From: Andrew Wood <Andrew.Wood@arun.gov.uk>
Sent: 17 January 2020 14:51
To: Planning.Responses <Planning.Responses@arun.gov.uk>
Subject: FW: Planning Consultation on A/113/19/DOC - Angmering site

From: Sarah Burrow <Sarah.Burrow@arun.gov.uk>
Sent: 21 October 2019 12:44
To: Andrew Wood <Andrew.Wood@arun.gov.uk>
Subject: RE: Planning Consultation on A/113/19/DOC - Angmering site

APPLICATION NO: A/113/19/DOC

Site Address: Crete Nursery Dappers Lane Angmering BN16 4EN

5.13E-04

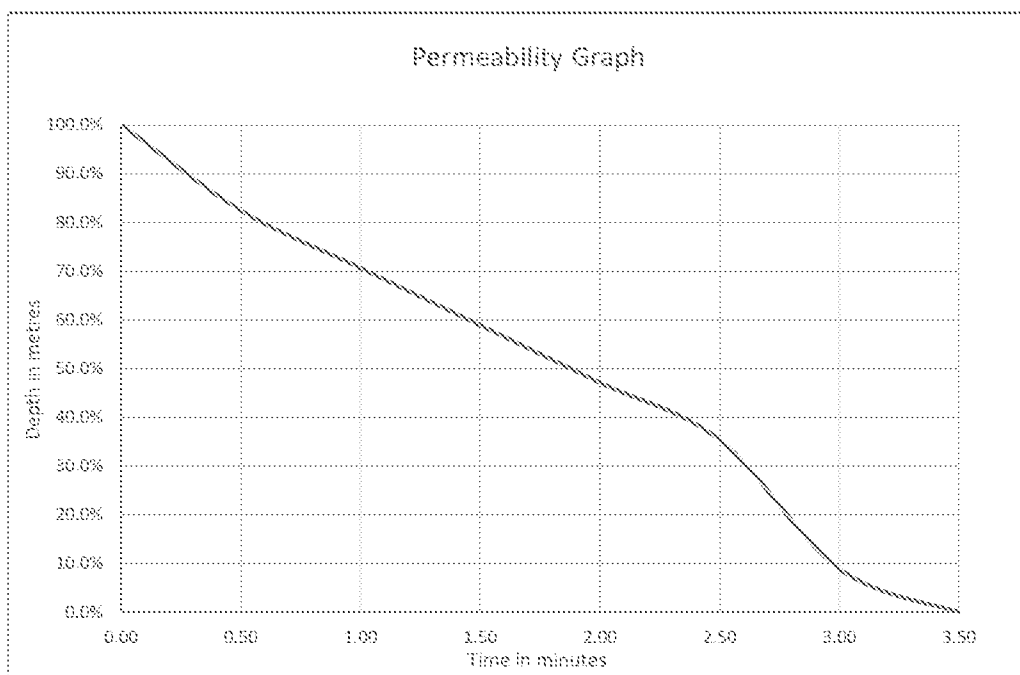
2. Infiltration testing was completed at one location and gave rates of $5.13 \times 10^{-4} \text{ms}^{-1}$ at 0.9m depth. This is deeper than the highest recorded groundwater levels and the scarcity of infiltration testing is of significant concern. We would have expected at least one further infiltration test, ideally two further tests at the proposed location and depth of infiltrating structures.

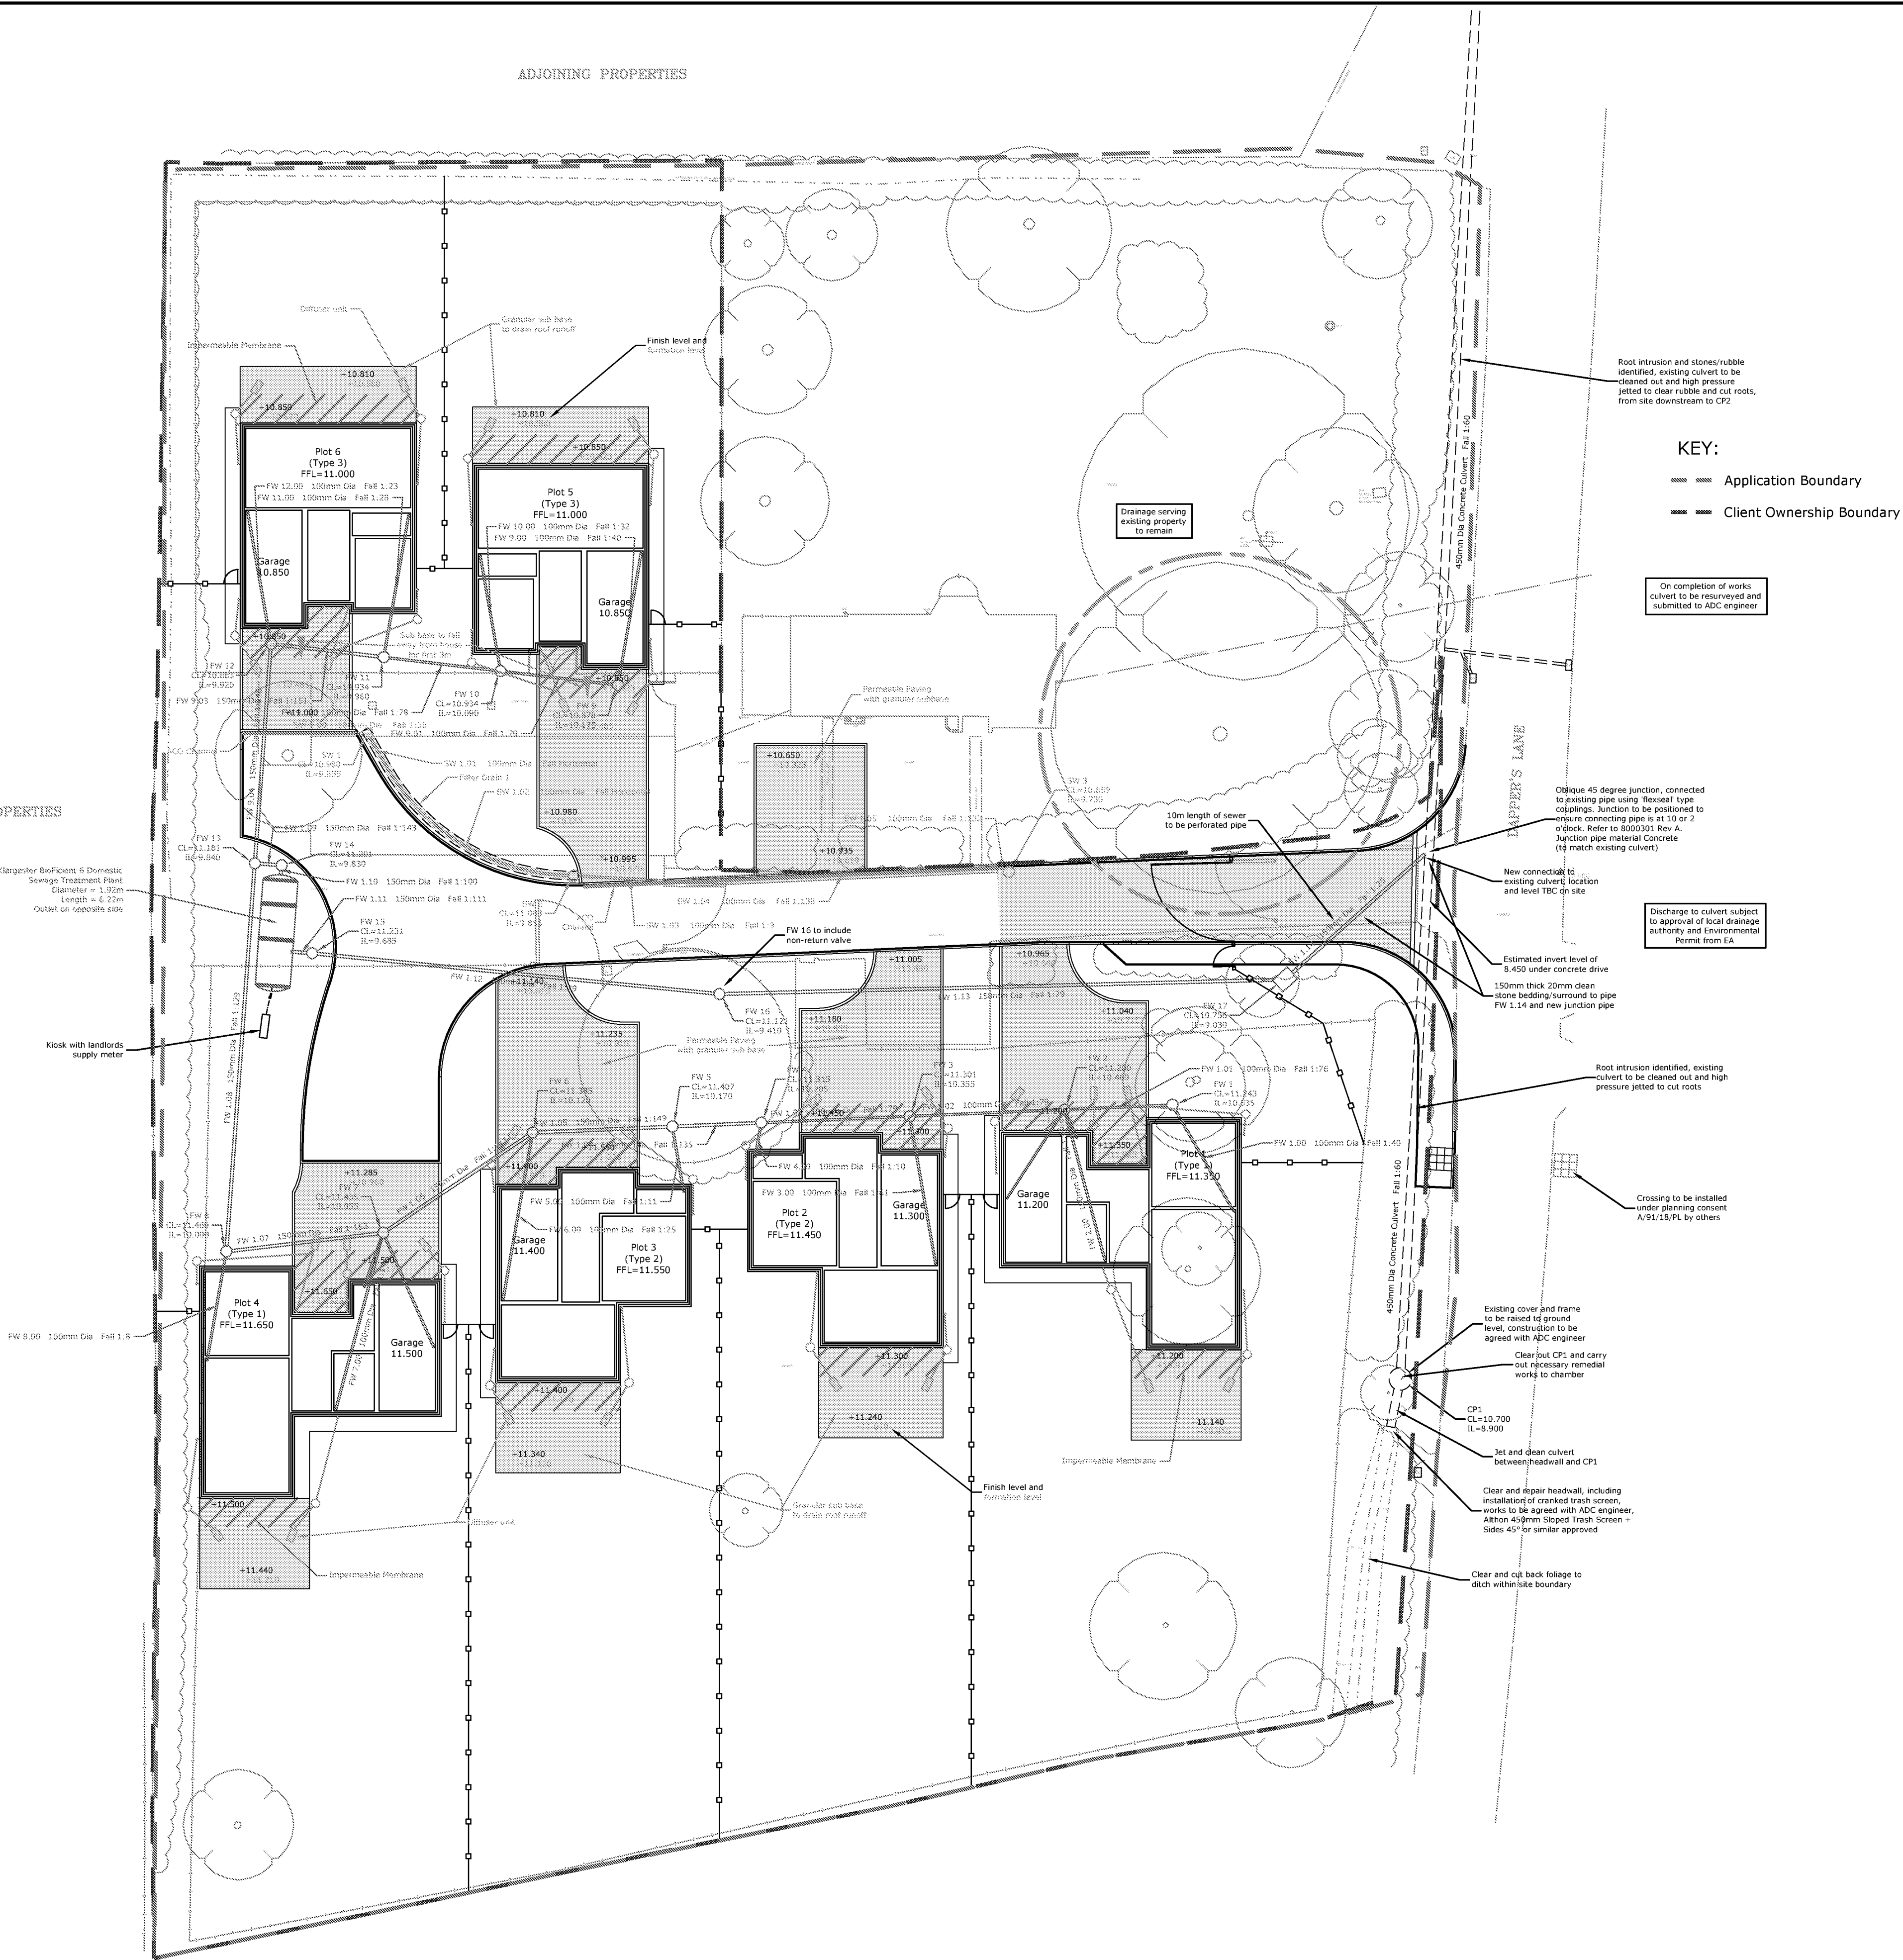
10. Catchpits must be provided upstream of all connections to permeable paving. Please ensure the location of rwp, catchpits, and connections to permeable areas are clearly shown on plan.

11. Please provide invert levels and cover levels of all inspection chambers, manholes, filter drains, etc. Please also ensure that finish and formation level of permeable paving is clearly provided on plan.
